Construction of an electrical transformer station including fenced enclosure
Rear of Widdowson House Shripney Road Bersted PO22 9NG

Re: Widdowson House, Shripney Road, Bognor – Proposed Electrical Transformer Station

Application No. BE/15/11

Client Sime Darby London Ltd.			
Job Title Former LEC Factory - Elec Transformer Station			
Drawing Title Site Location & Block Plans			
Drawing No.	3593/33	Revision	C
Scale As shown @A1	Date 16.12.10	Drawn By AG	Checked By -

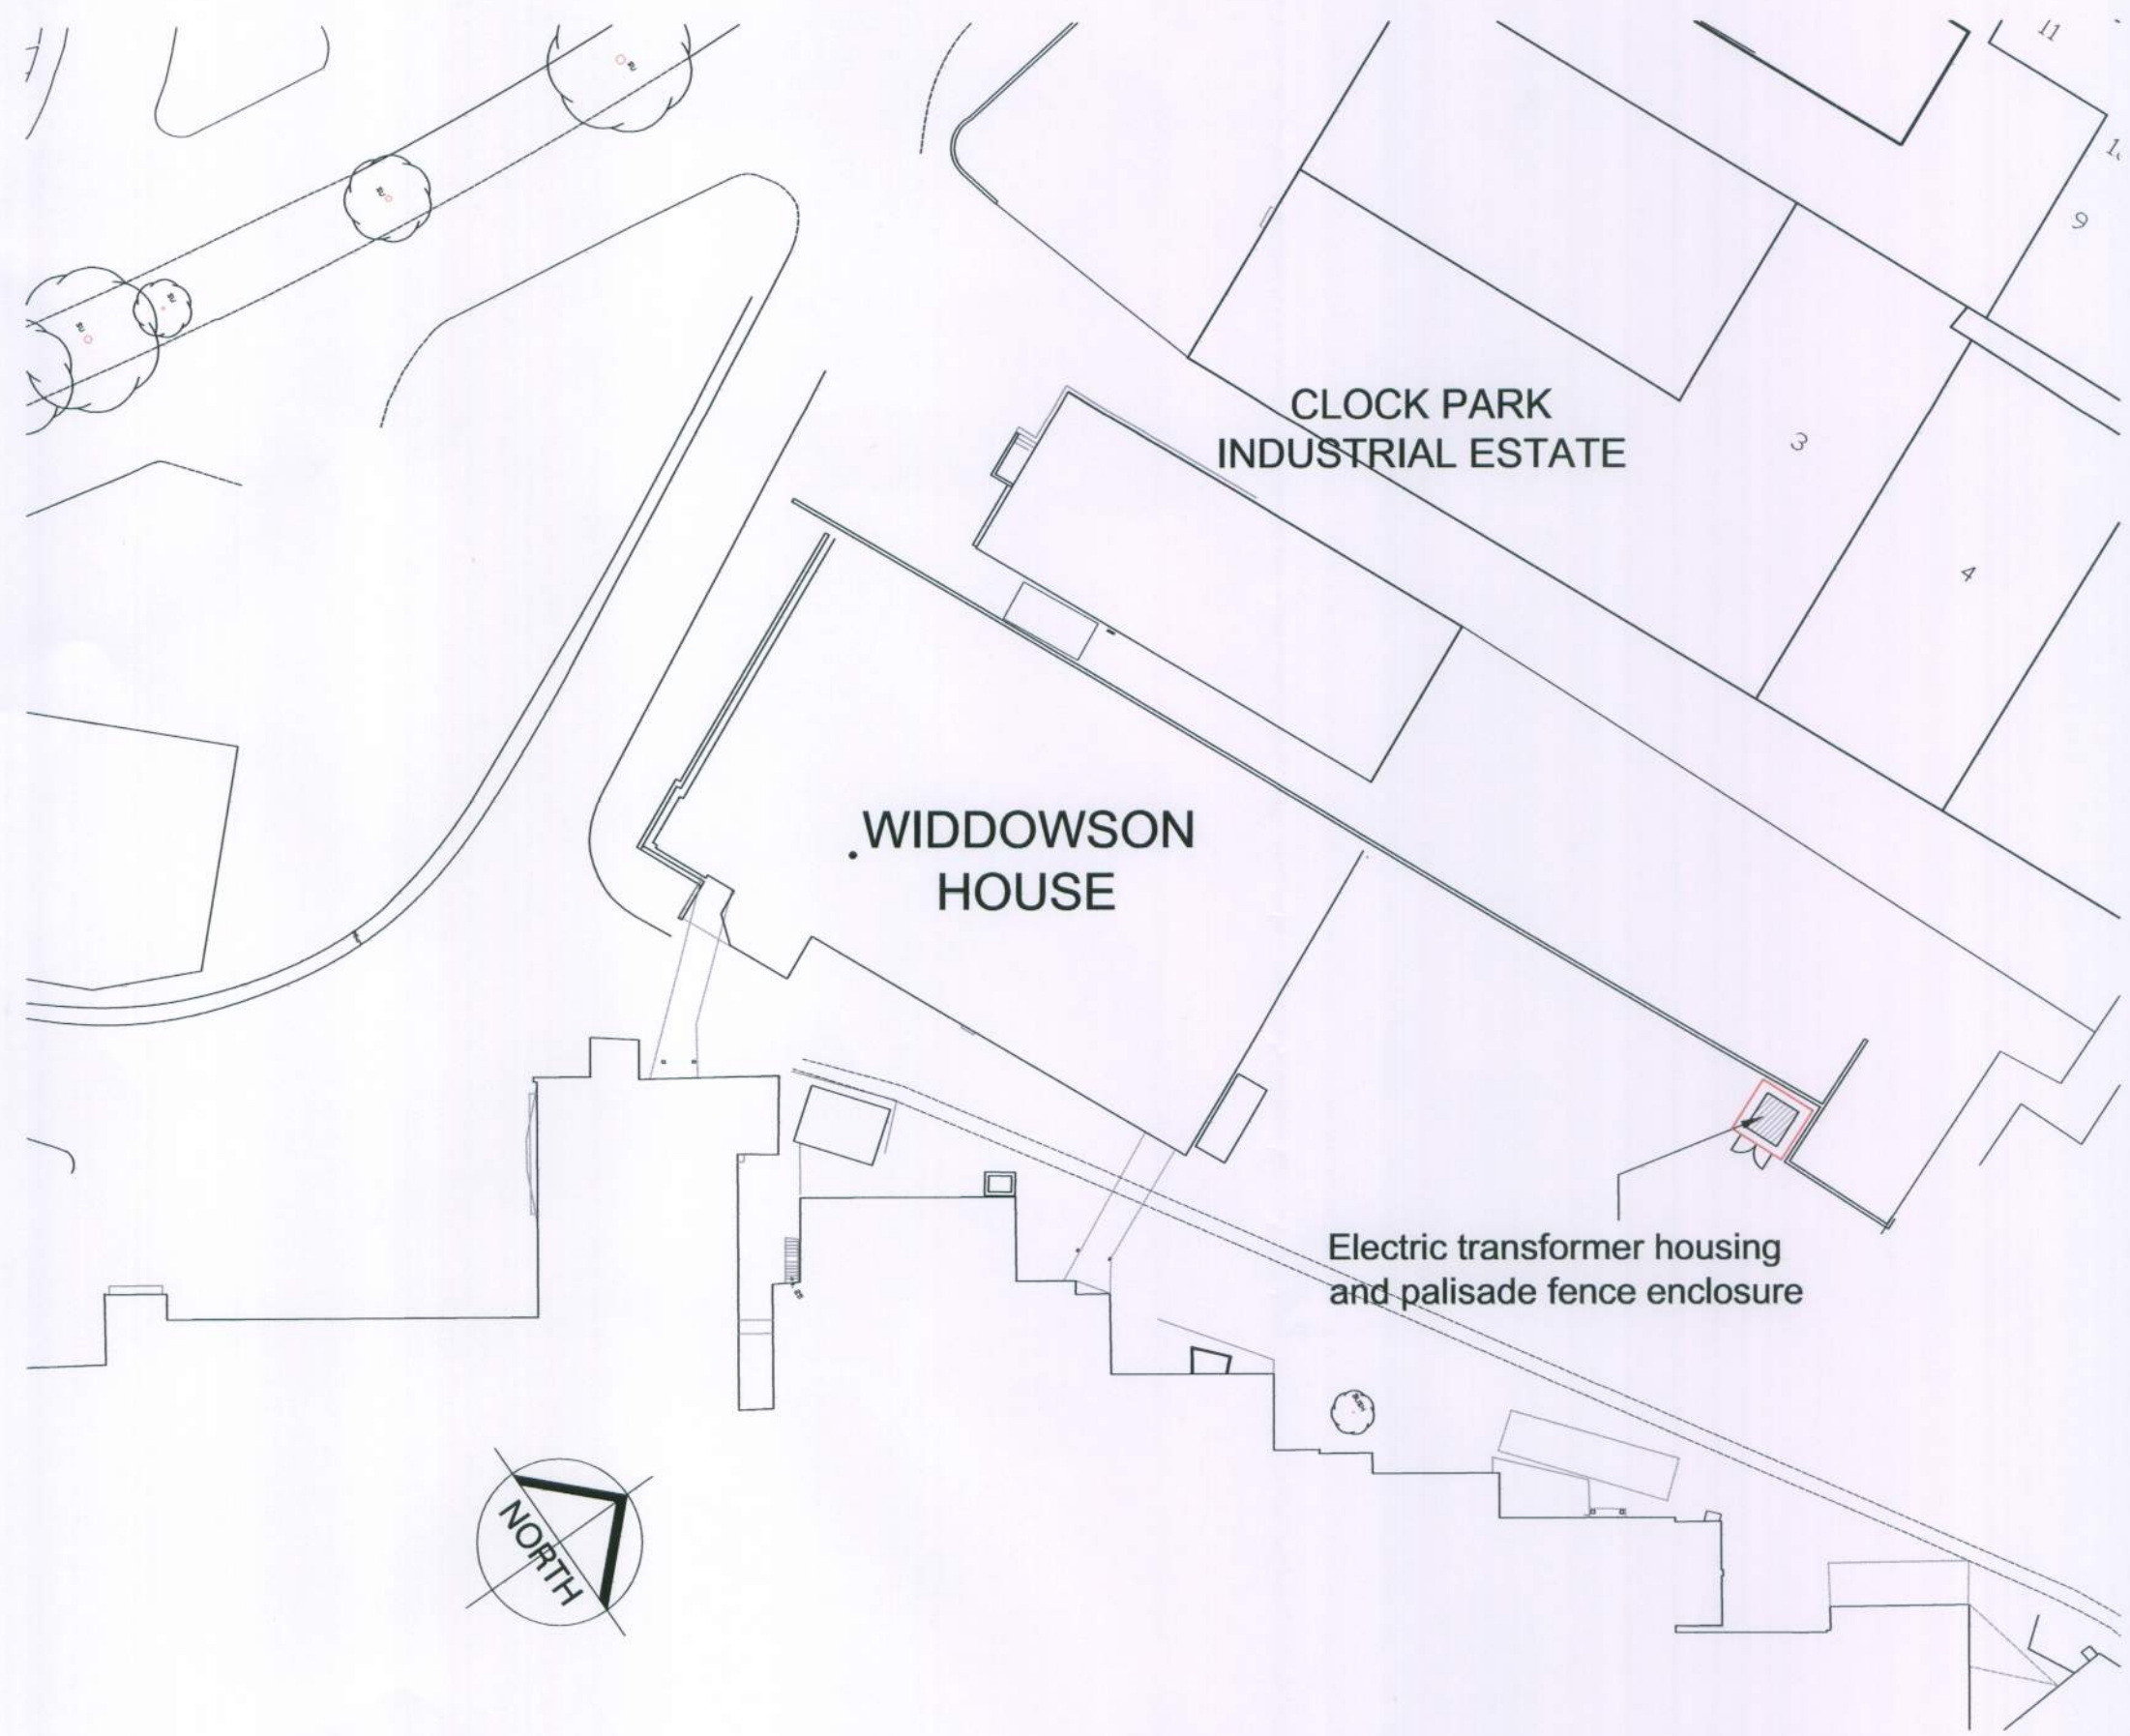
We refer to the submission on 8th February 2011 of a planning application (ref. BE/15/11) for consent to construct an electrical sub station with housing and fenced enclosure at the above premises. In order not to compromise possible future expansion of the Widdowson House factory and its associated service area, our client has instructed that the siting of the sub station be altered to an alternative location.

We hereby submit substitute drawings numbered 3593-33 Rev. C and 3593-34 Rev. C showing the new location for the sub station and revised contextual elevations. We also submit a revised Design & Access Statement Revision A dated 17th February 2011.
